Environmental Health.

APPLICATION FG/206/17/PL

Site Address: Land at Asda Superstore Littlehampton Road Ferring BN12
6PN

Description of Works: Installation of a Six Pump (12 Filling Position) Petrol Filling station, Drive-to- Pay Kiosk & associated works including Jet Wash, Air/ Water Services & Vacuum Equipment

Drawing Title
**PETROL FILLING STATION
FORECOURT LIGHTING PLOT**

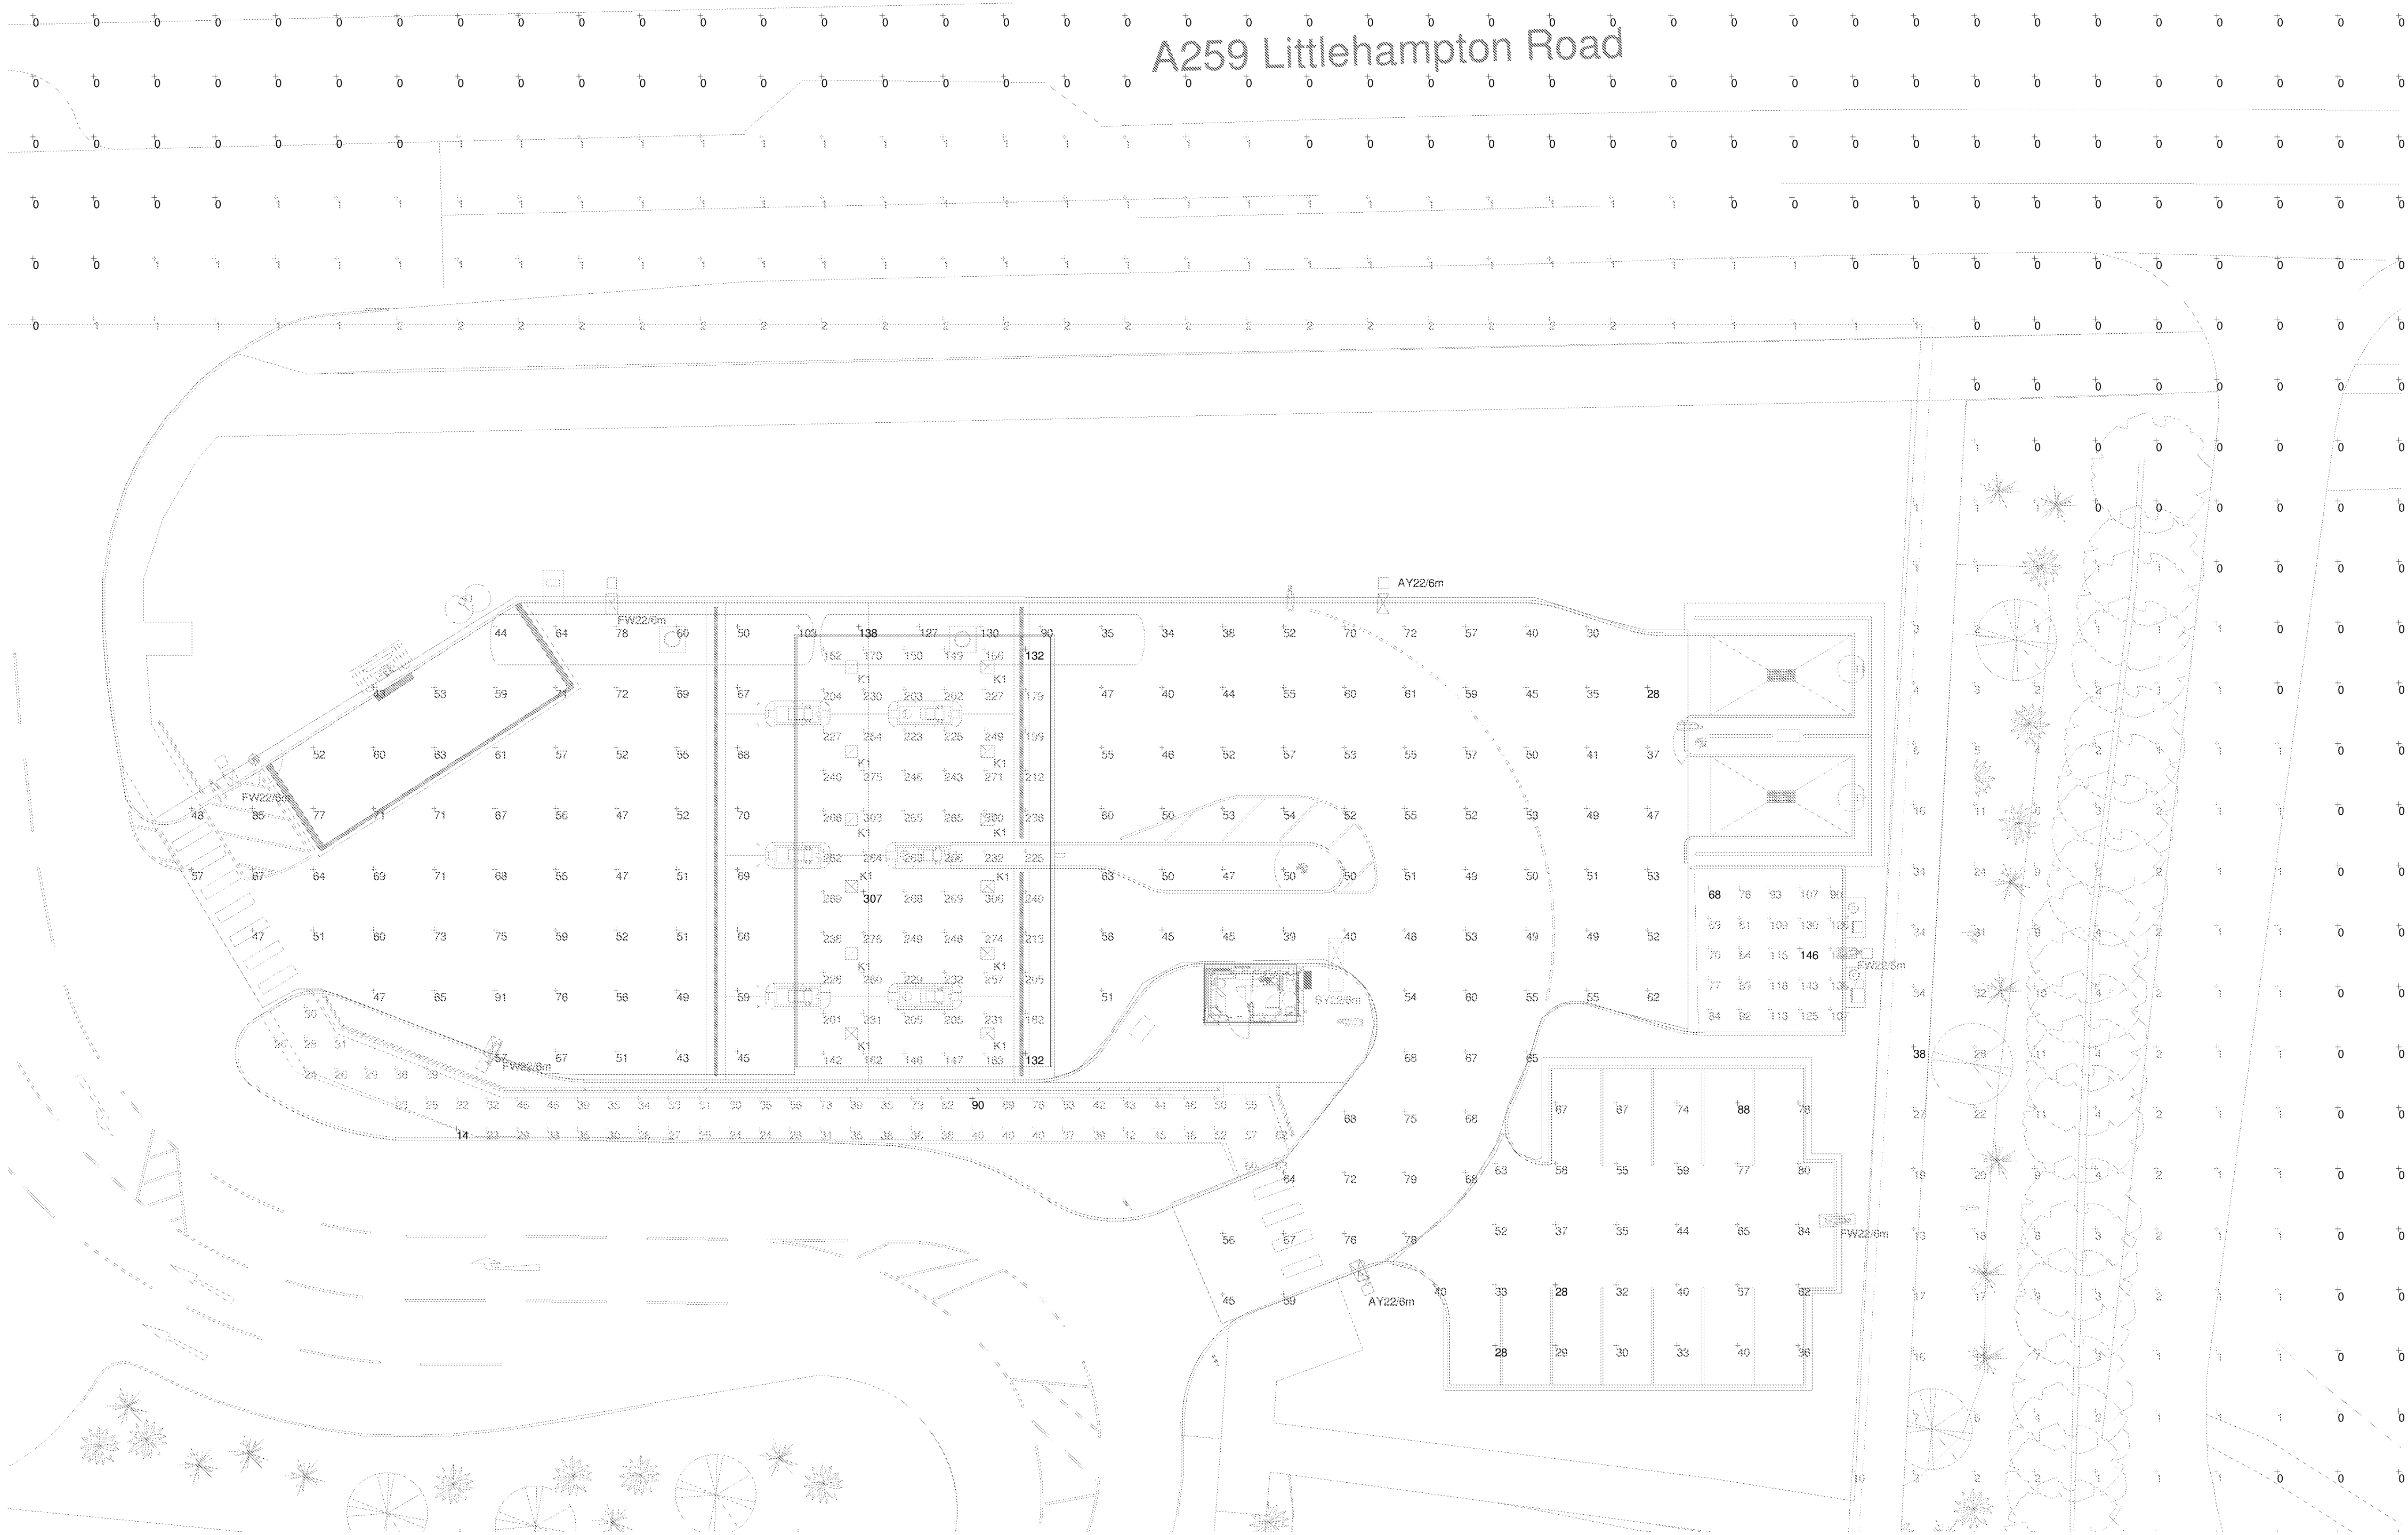
Lighting: External Lighting in association with this development shall comply with the Institute of Lighting Engineers Guidance Notes for the Reduction of Obtrusive Light, Obtrusive Light Limitations for Exterior Lighting Installations for Zone E3, Suburban. Special consideration to be given in respect of housing to the immediate east of this proposed development.
